Hornton Parish Council

[Planning application: 21/00517/F - Planning register | Planning register | Cherwell District Council](#)

Response to revised LVIA - 15/5/2021

PROJECT: Wroxton Motor X
CLIENT: Ms S Kerwood
TITLE: Viewpoint Figure Sheet
DATE: 3 March 2021

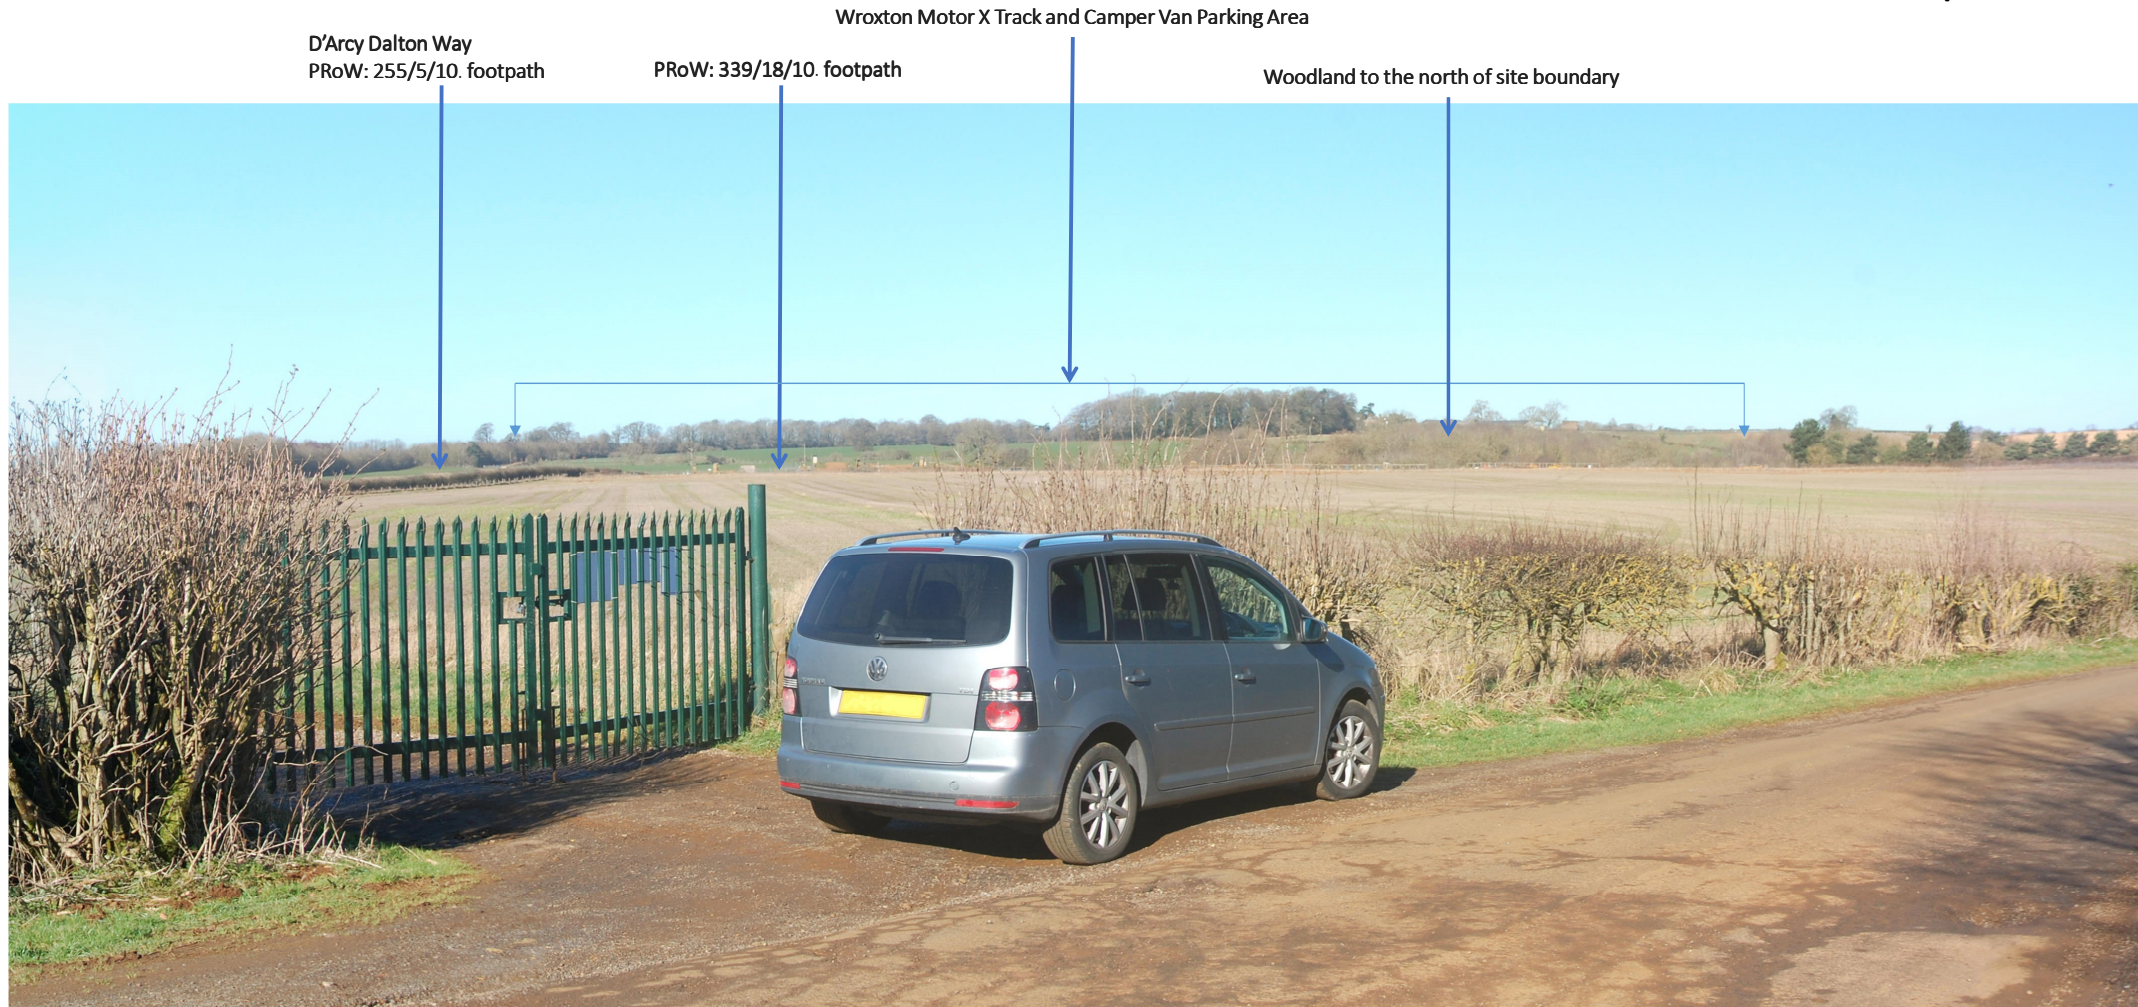
3.16 The footpath runs *directly* alongside the track - forget the 500m claim.

And, vitally, there is no mention (we assume another deliberate omission in briefing of the author and/or

inadequate research) of the new, OCC re-routed footpath to run, very worryingly, directly *alongside* the only access track to the circuit.

Unbelievably, this new footpath route will run precisely along the edge of the site's access track

route – see picture below. What kind of visual amenity or impact is that? Not to mention the unpleasant effects for walkers of MX engines roaring on the track, which they tolerate already on race days, of course.
